Submission to: NSW Department of Planning, Housing and Infrastructure Application: SSD-82052708 —
Proposed Data Centre, 12 Mars Road, Lane Cove West

Date: May 2026

I object to this application in its entirety and ask that it be **refused**.

# 1.9 Existing Trees to be Removed

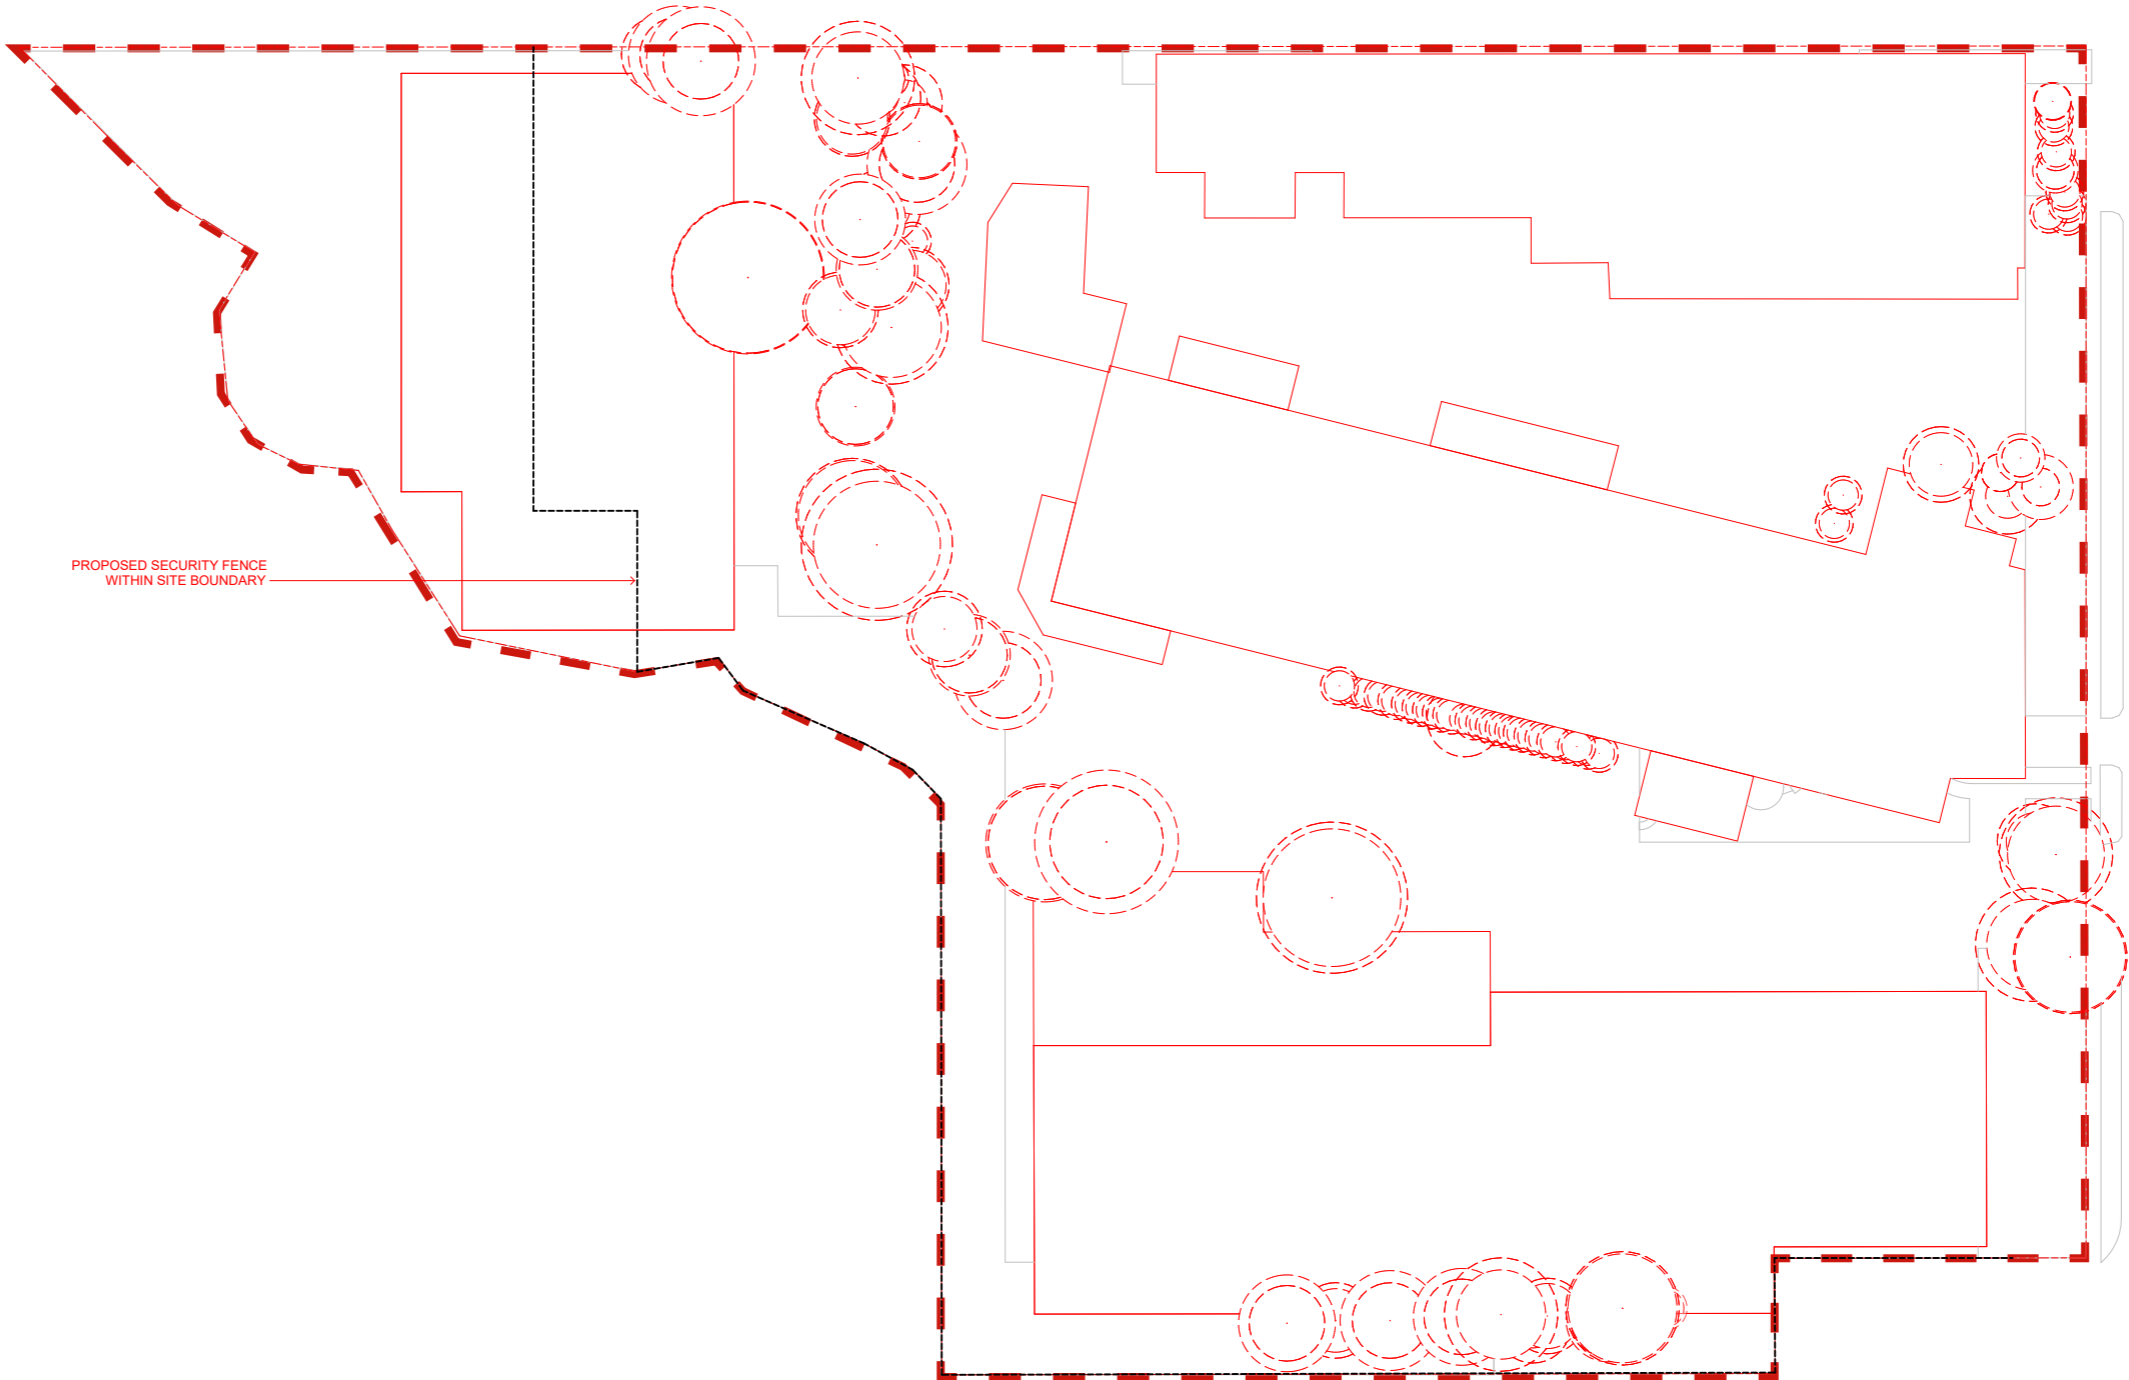
Document	Trees Removed
Main EIS (Table 9 and throughout)	90 trees
Arborist Report / Landscape Report (per SIA Section 6.2.2.1)	82 trees
Social Impact Assessment (Section 6.3)	121 trees including 7 Category A high-retention-value trees

The Social Impact Assessment — prepared by the same firm as the main EIS — records 31 more trees being removed than the main EIS states. More significantly, the SIA (Section 6.3) expressly acknowledges that the proposed canopy cover of 24.7% does not meet the Lane Cove DCP's 35% requirement for industrial developments. This admitted DCP non-compliance appears in an appendix and is absent from the main EIS.

DRAWING TITLE
EAST ELEVATION

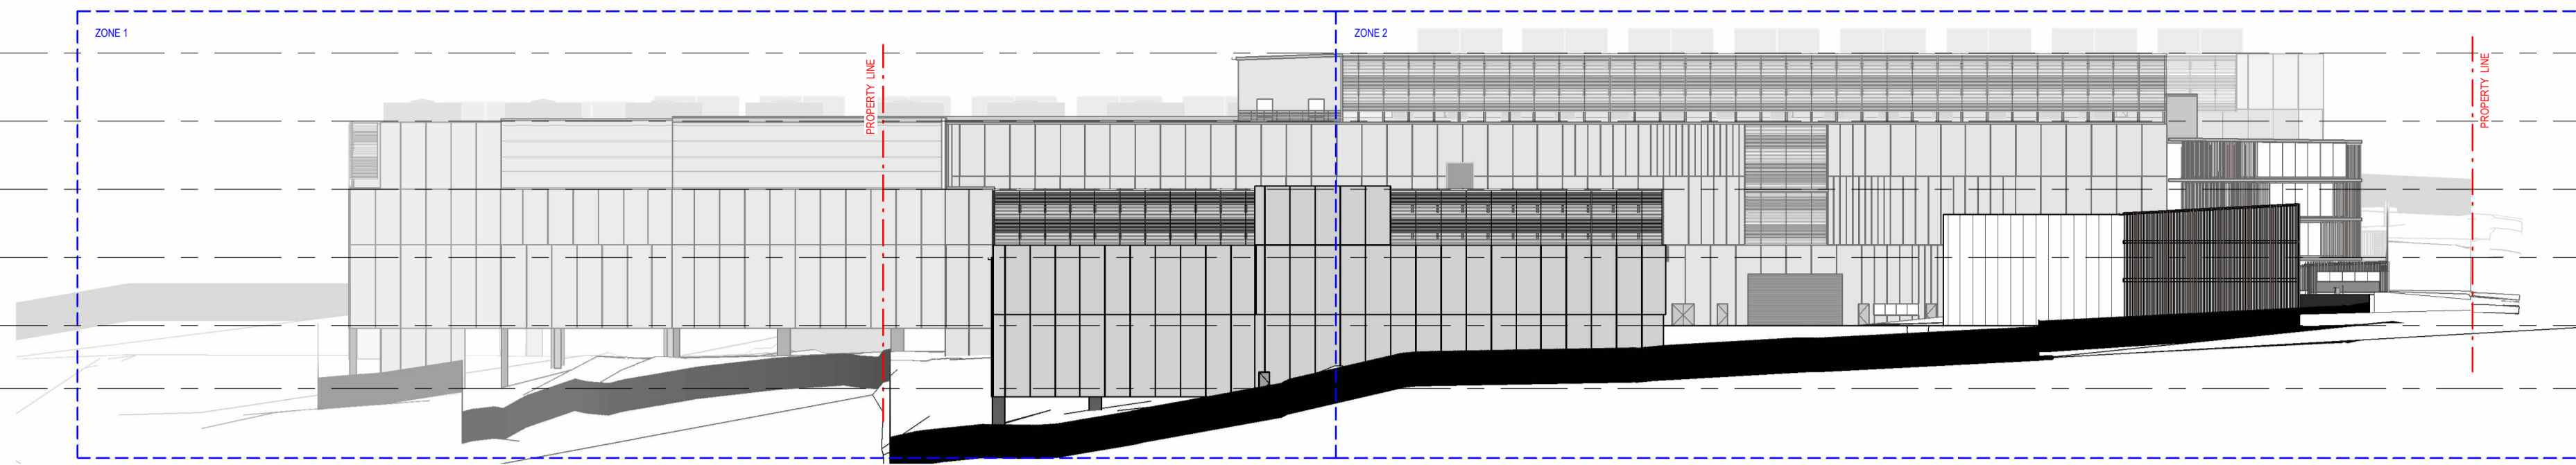
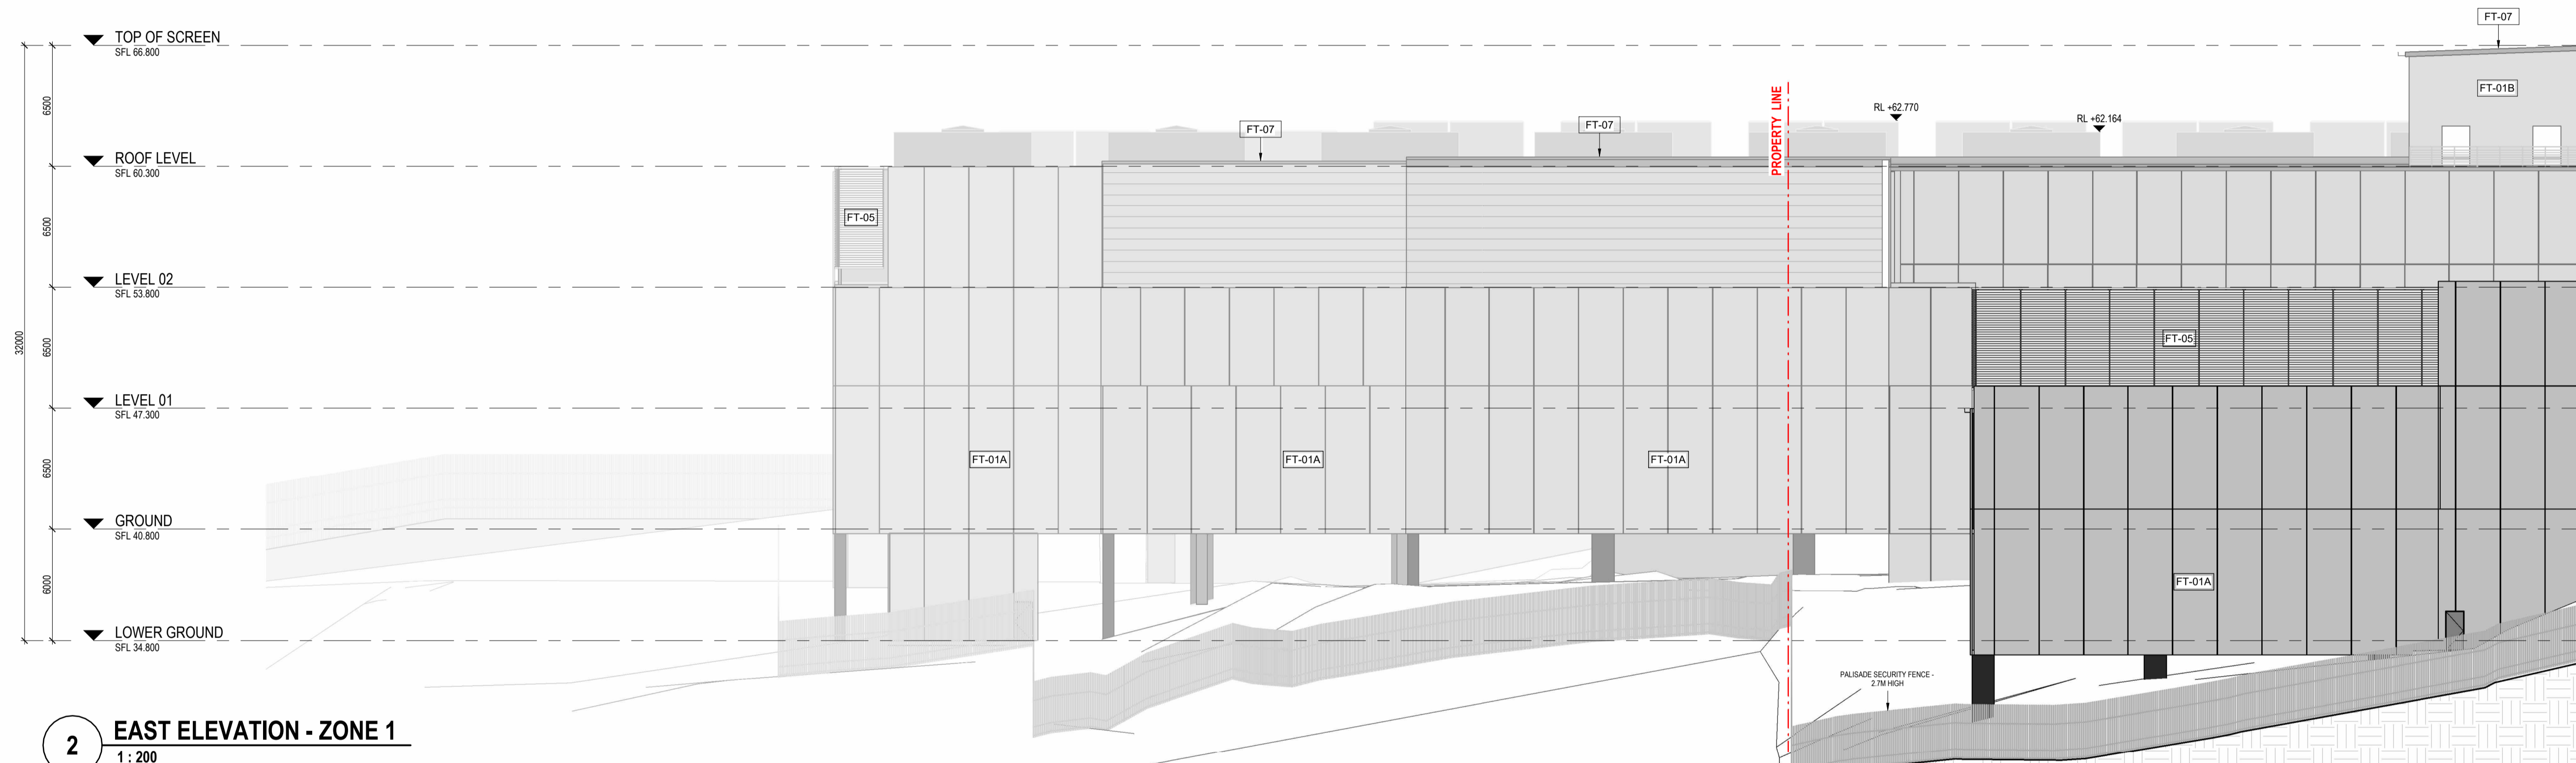
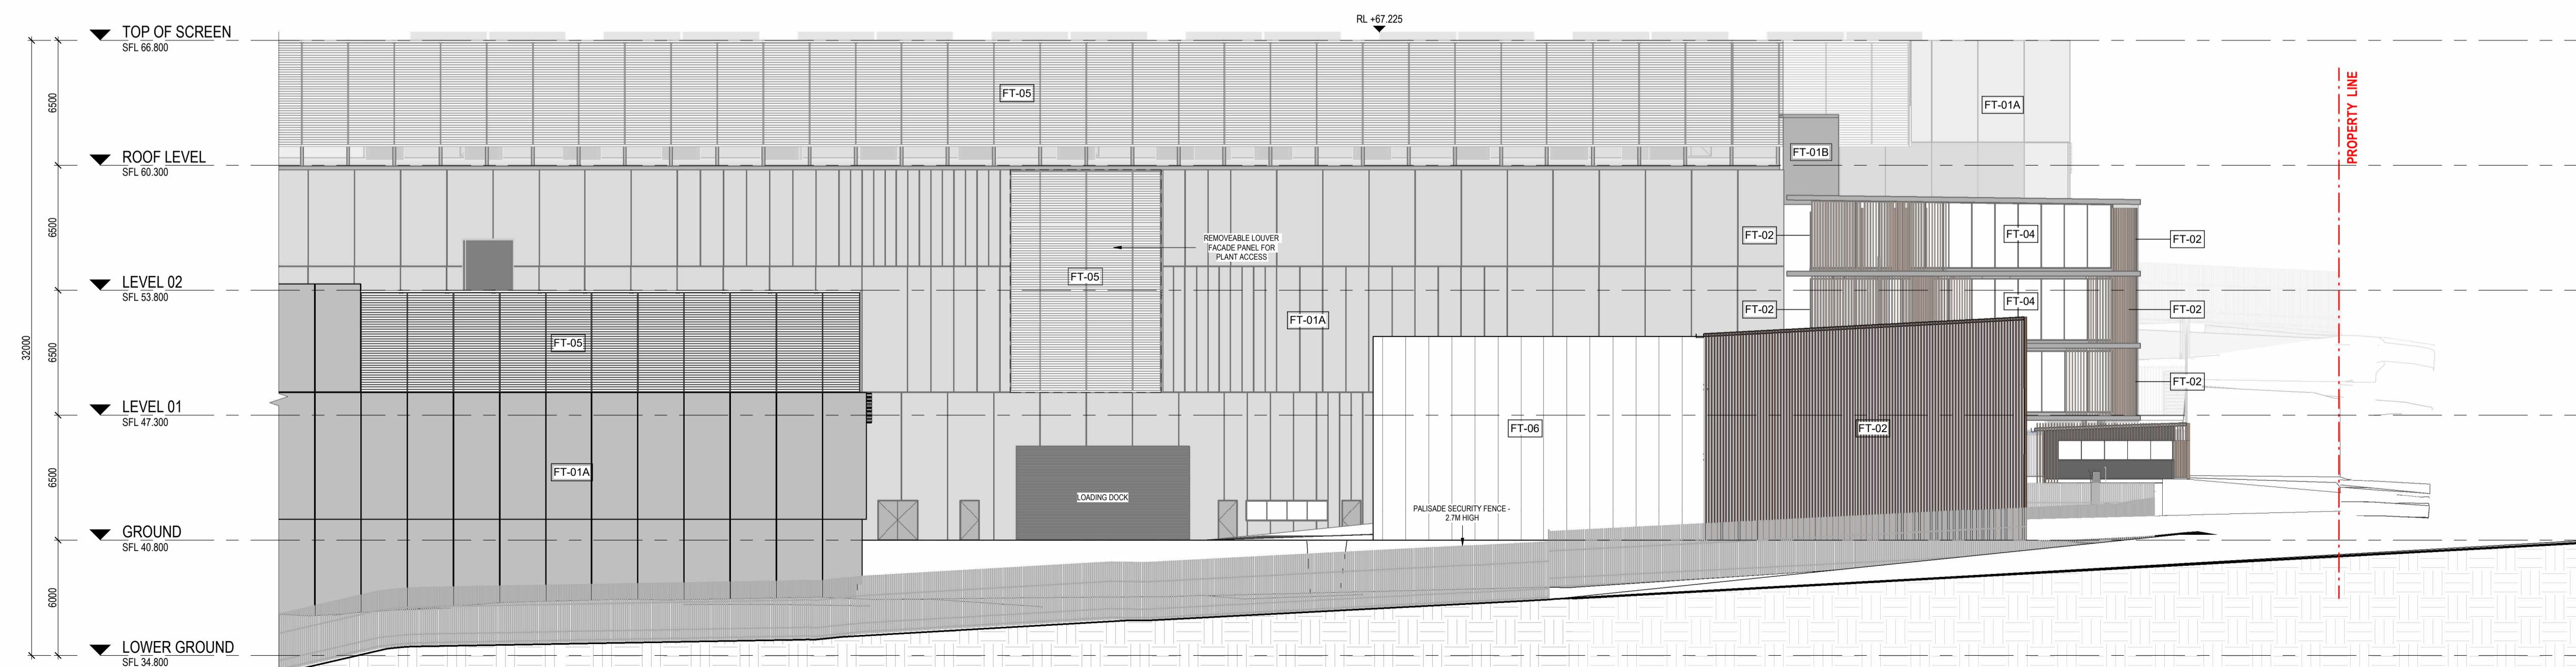
The document also characterises the height variation near the eastern boundary as "only a very small variation." My property is 6.3 metres from that boundary. The building reaches between 28.3 and 33 metres at this interface — an exceedance of between 57.2% and 83.3% of the 18-metre standard. Lane Cove Council's submission states the Clause 4.6 variation is not supported, that the greatest height breaches are located toward the most sensitive interfaces, and that no treatment has been provided along the eastern and southern facades facing homes, the Community Nursery and bushland.

Question 8: What compliant 18-metre scheme was tested, what lower-impact alternative was modelled at the eastern and southern residential and parkland interfaces, and what specific impacts — on the residents of Banksia Close, on the Community Nursery, and on Blackman Park — would be avoided if the building complied with the height control at those interfaces?
